**Access point AB-AP5 (adjacent to Rose Cottage, Church Hill, Burstall).**

Drawing title: **AB-AP5
Proposed Visibility Splay
Concept Design
Sheet 1 of 1**

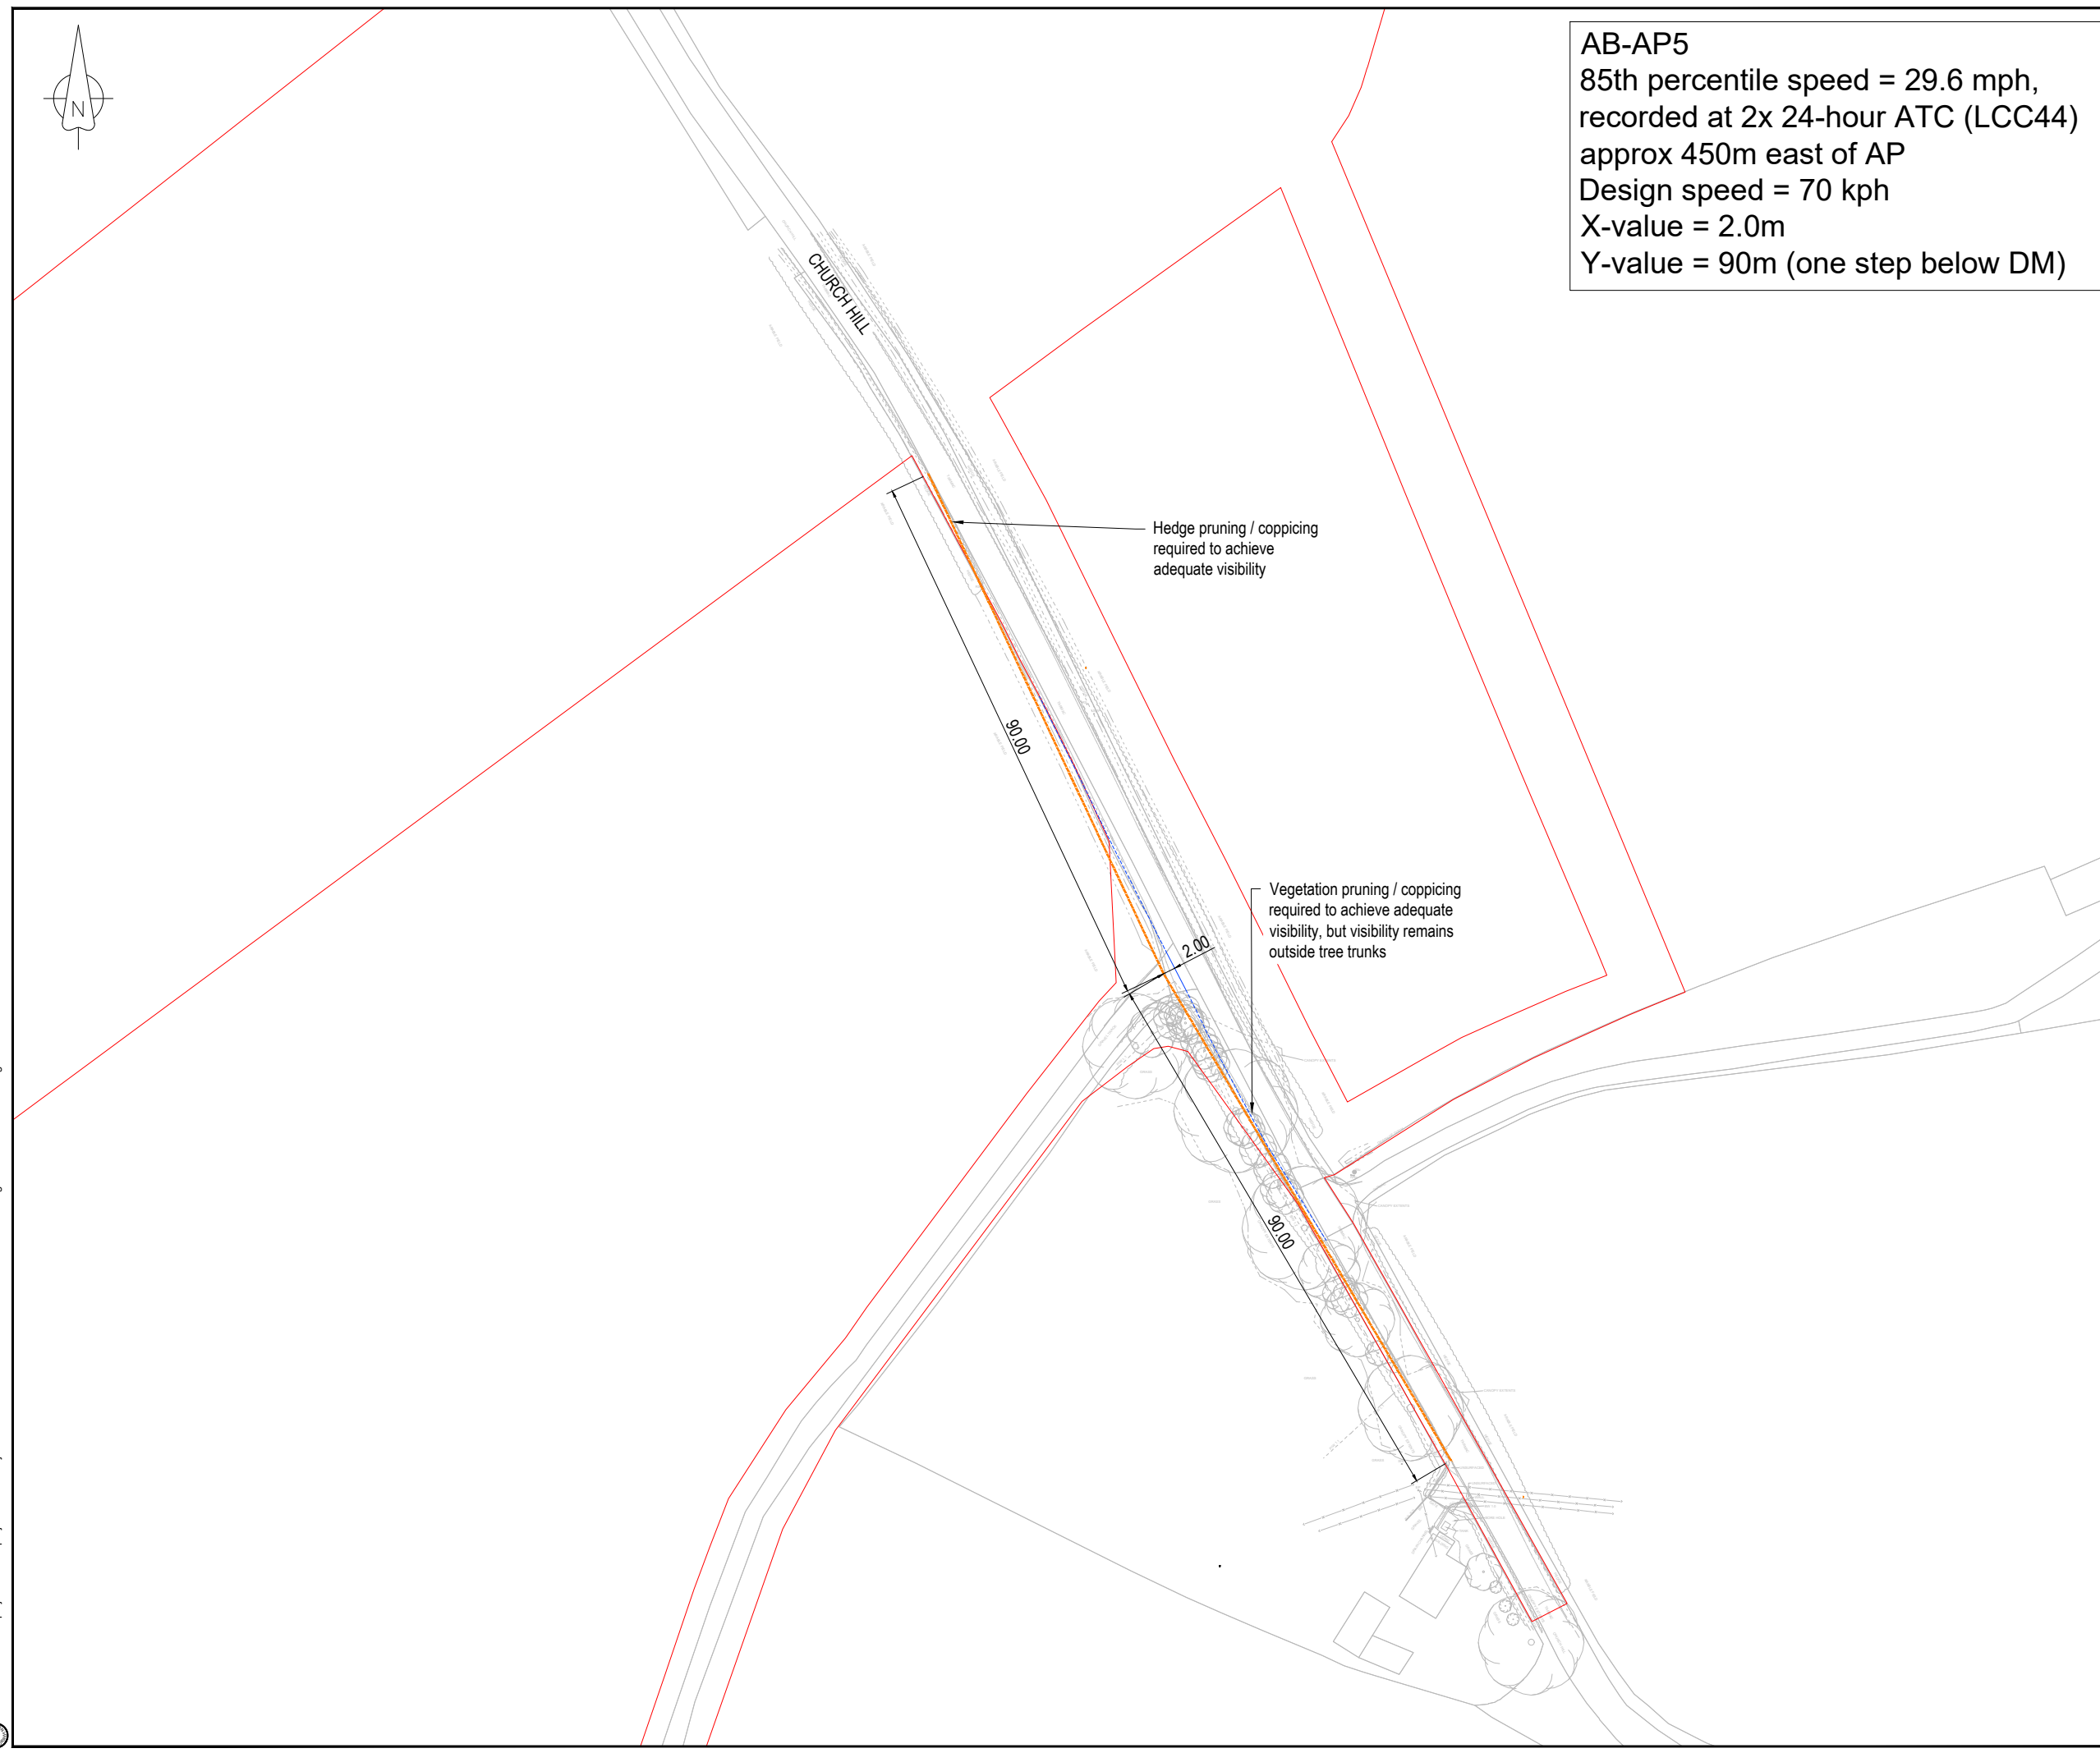
- 2) Despite the visibility splay requirement increasing from 45 to 90 meters since ISH3, the Applicant has produced a drawing showing a possibility of achieving this which “does not interact with any surveyed tree trunks”. However, no mention is made of any bellmouth requirement which, if constructed according to the original plan, would invalidate this statement. What are the Applicant’s intentions in this regard? Again in document 8.9.5, the Applicant states: “the Applicant’s view that developing large bellmouths and undertaking major road improvements for temporary accesses would be disproportionate”. I agree. Is it the case that the standard bellmouth would not now be used at AP5?
